July 16, 2021

**Project Name:** Super Star Car Wash - Falcon, CO  
**Project No.:** 020441-01-001 // PPR-21-008

This letter is in response to the letters dated March 11, 2021 – April 14, 2021.

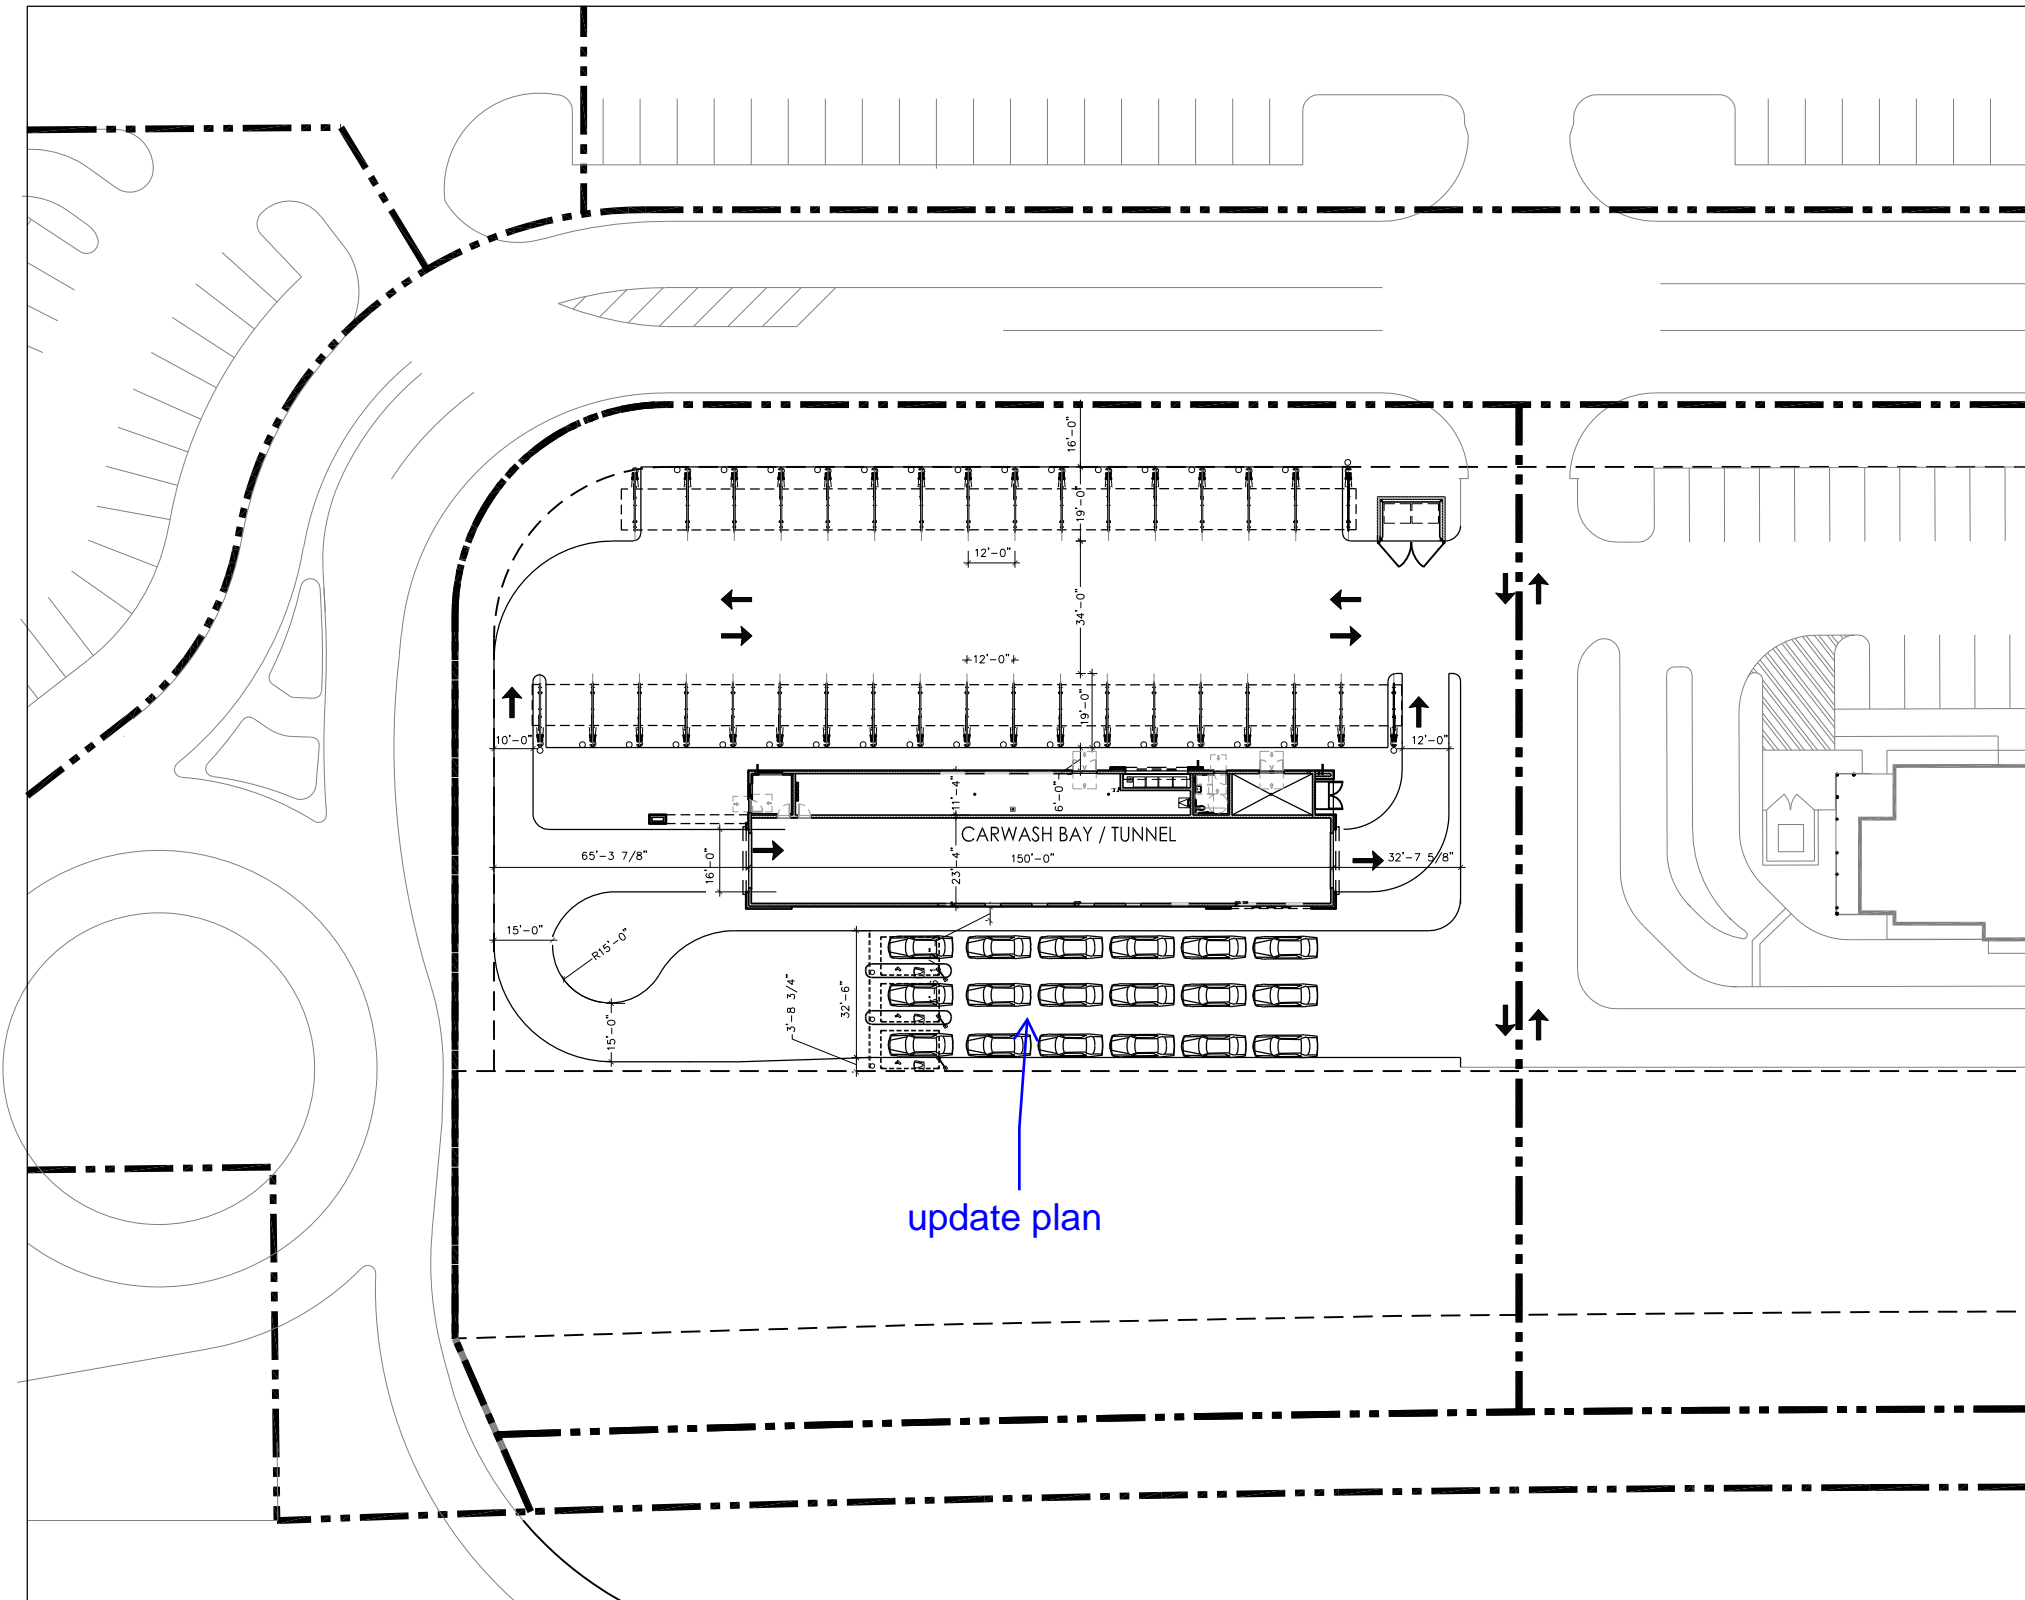
6. Provide the layout from the site development plan.  
**Response: Latest site plan added into the revised TIS.**
7. Provide comparison to the subdivision TIS values.

**Response: A trip generation comparison has been added. A Saturday comparison could not be made because that analysis was not completed in the Original TIA.**
